Our Case Number: ABP-316051-23

Re: Renewable energy development comprising 9 no. wind turbines and associated infrastructure.
Umma More and adjacent townlands, County Westmeath.

Observation on Ummamore Renewable Energy Development. Case Ref: 316051

**Site Layout 1:5,000**  
**Sheet 1 of 2**

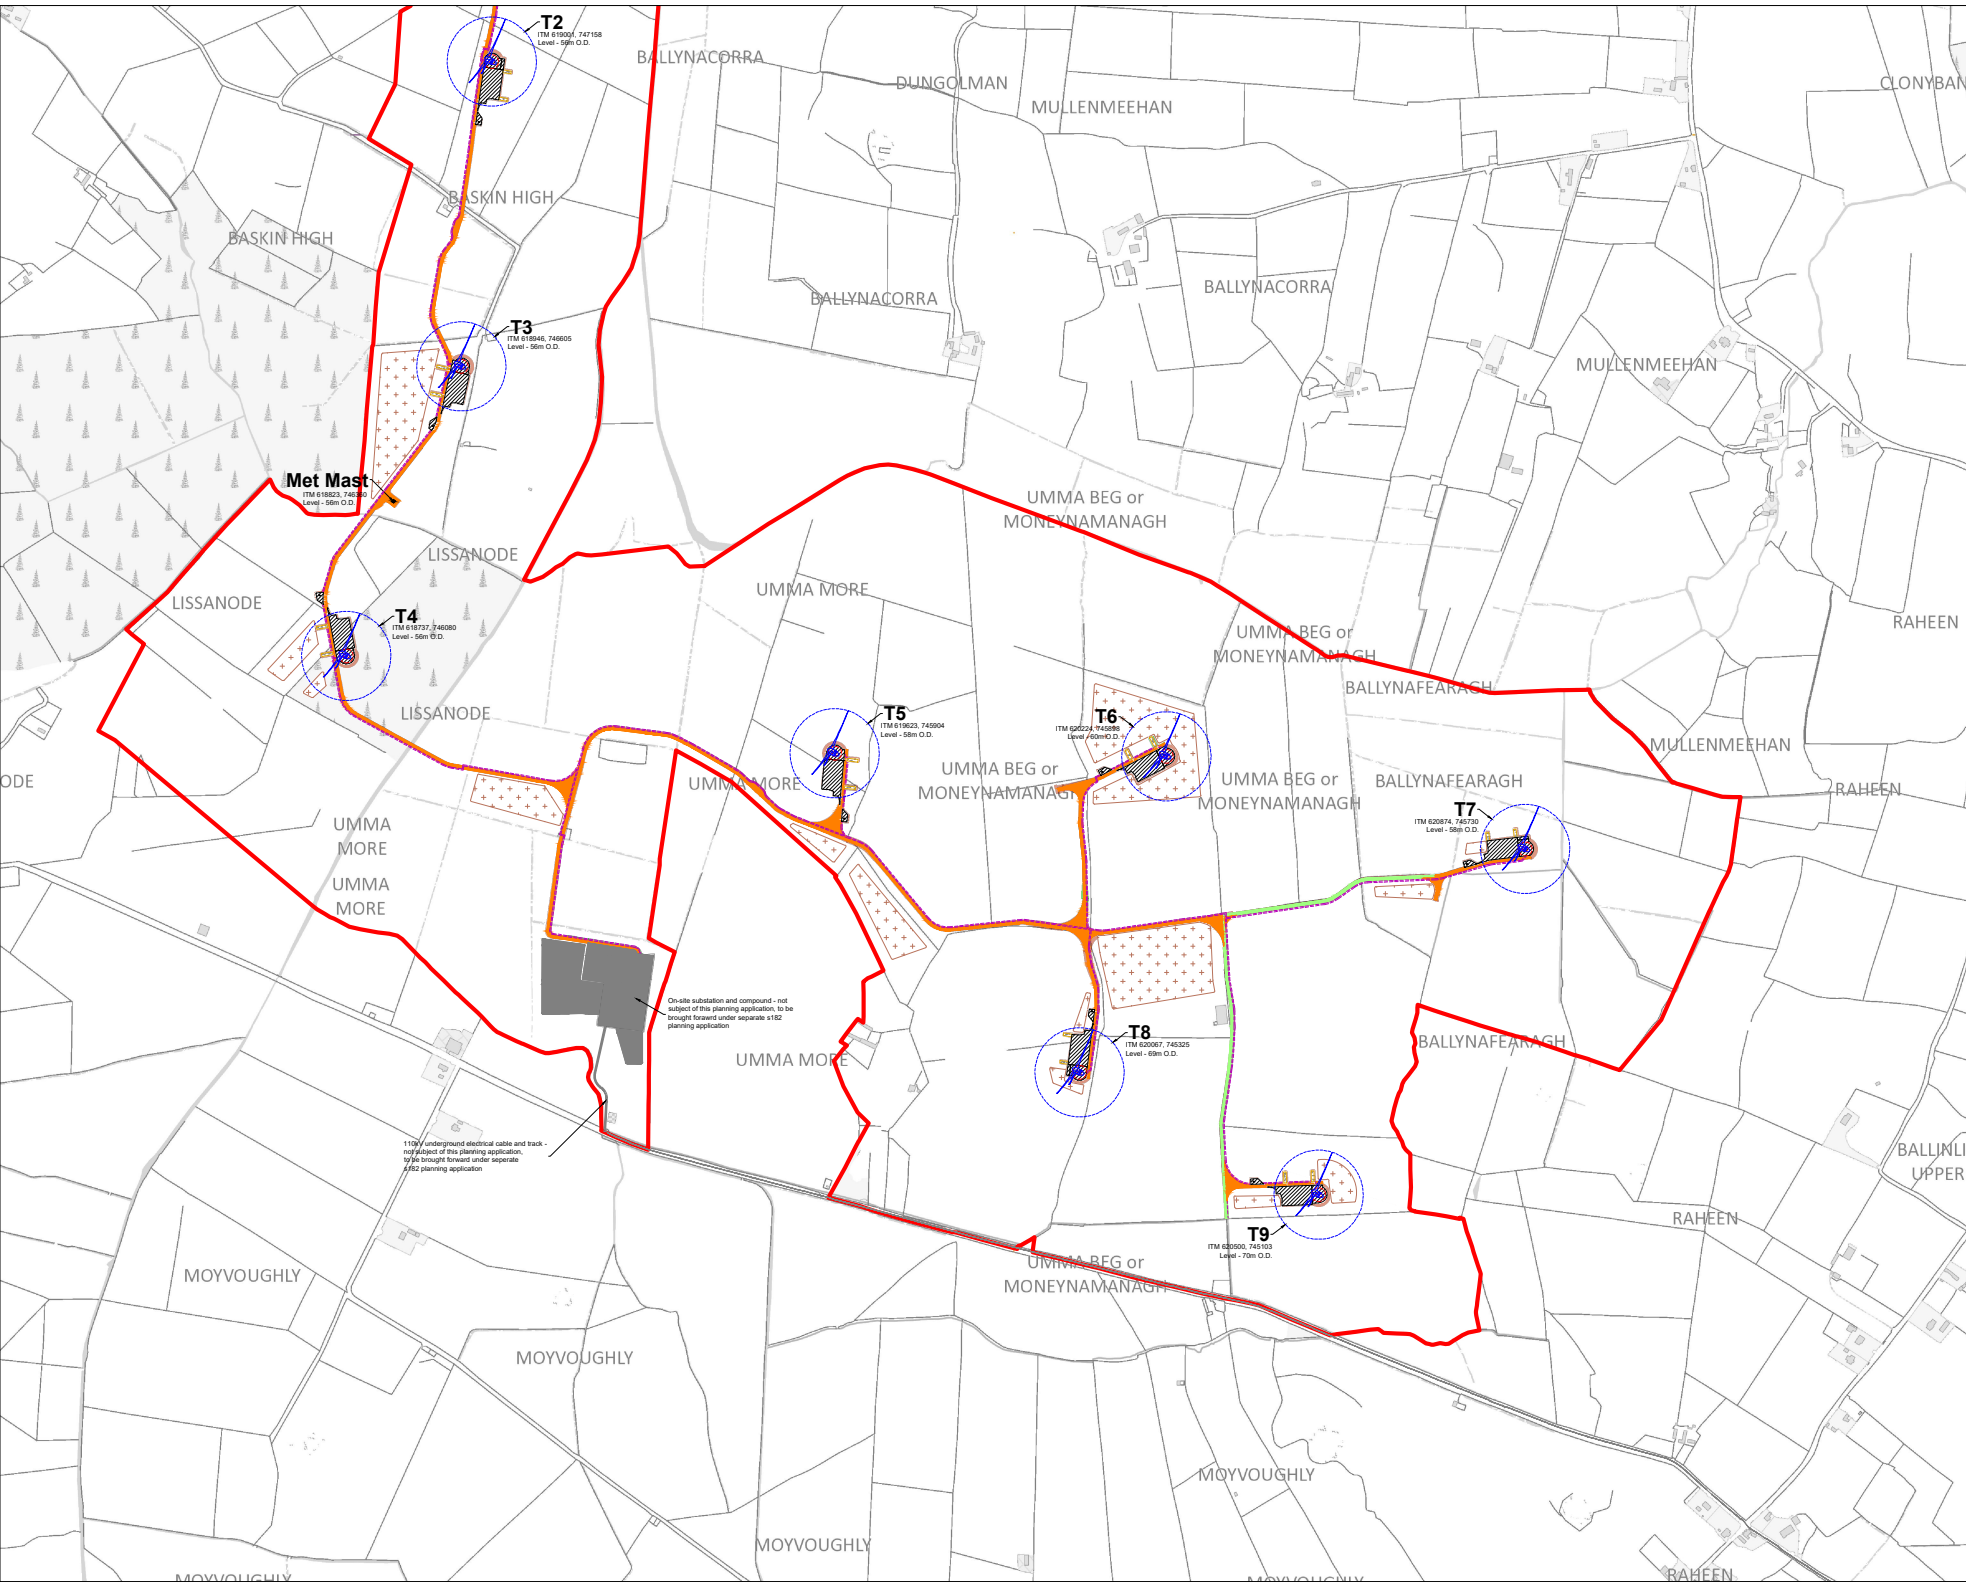
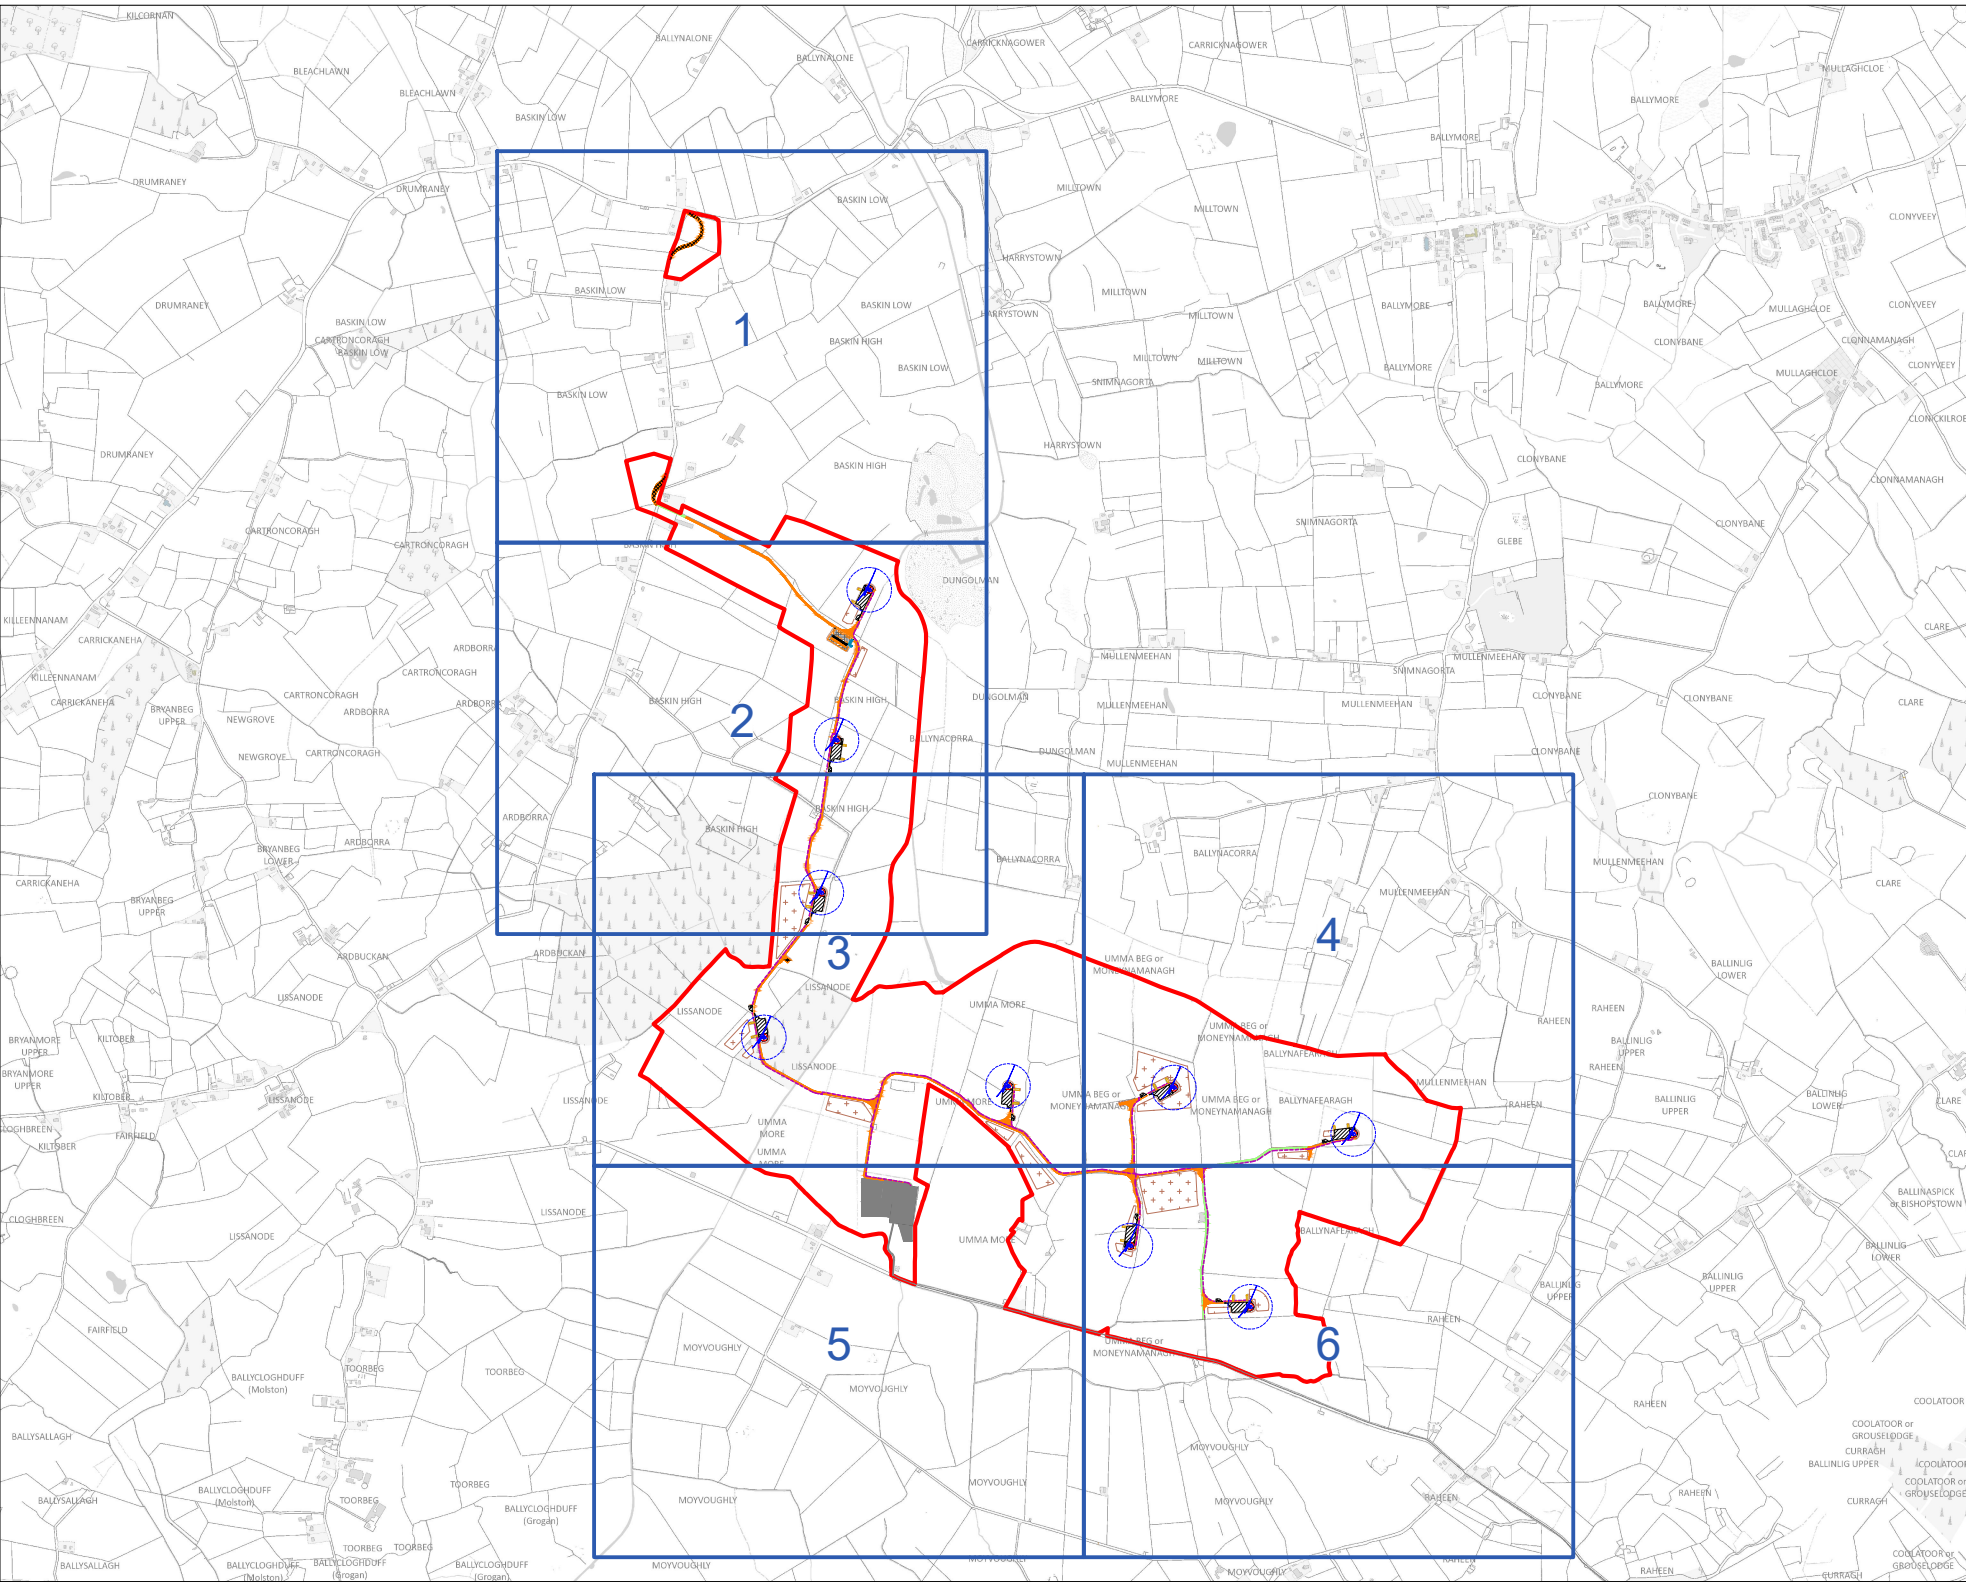
We believe that T4 and the onsite substation should not be permitted within such a close distance to our family home and land. The location of T4 is in breach of the Draft Wind Energy Guidelines which the Applicant has adhered to in previous applications and the substation could be positioned quite literally anywhere on site that is further away from our family home.

The positioning of the substation to the southern extremity of the wind farm site, so removed from the proposed internal road network makes no sense whatsoever. We believe that the grid connection should be going towards either Athlone or Mullingar so it would make more sense to have the substation located near the entrance on the Baskin Road.

Even with the chosen route to Tullamore in mind, surely it would make far more sense to position the substation somewhere between T8 and T9 where it would be along the internal road network and they could make use of an existing farm roadway to bring the cabling to the Umma Road. It would cut the distance of public road that would have to be disrupted and it would also be situated much further away from any residential dwellings.
